State Environmental Planning Policy (Transport and Infrastructure) 2021
State Significant Development Application - SSD-76555711
3-5 Help Street, Chatswood
Request for additional information

16 July 2025

SCALE: 1:200

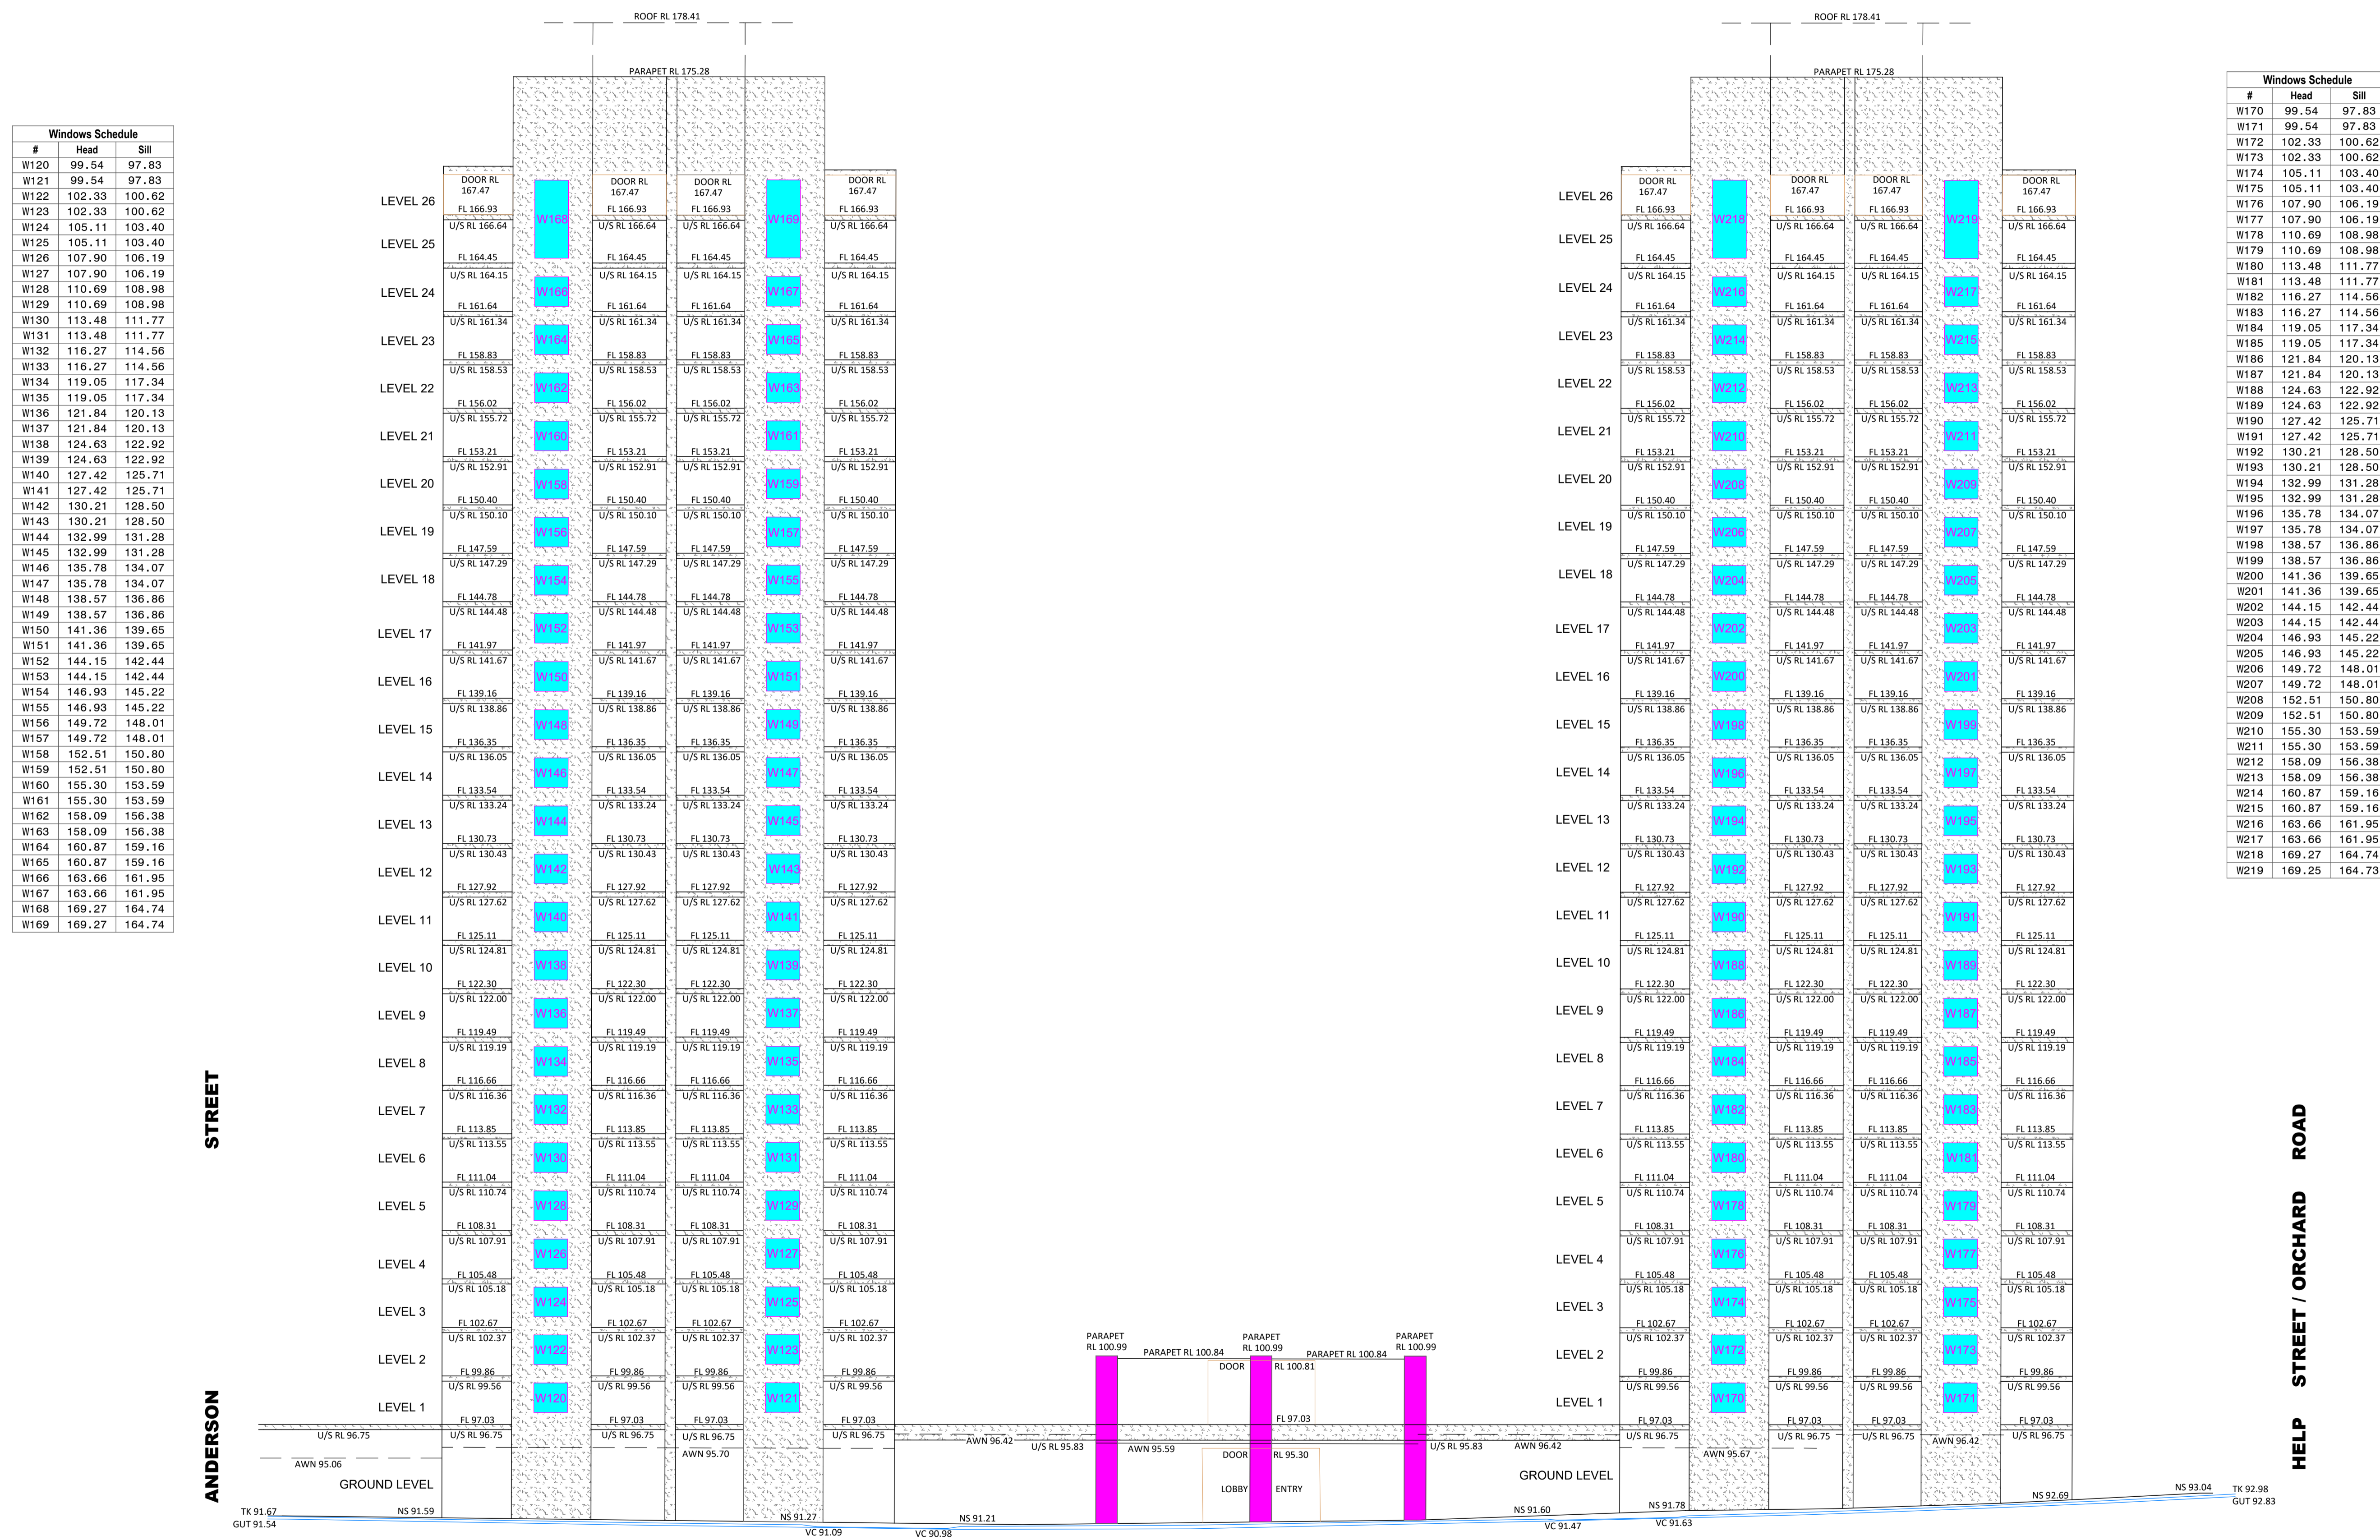
- a) **Survey Plan:** a registered surveyor verified detailed survey information showing the distance of the development to the rail corridor, specifically plan and elevation.
- b) **Ground Anchors:** confirmation of the extents of ground anchors, if required for shoring design.
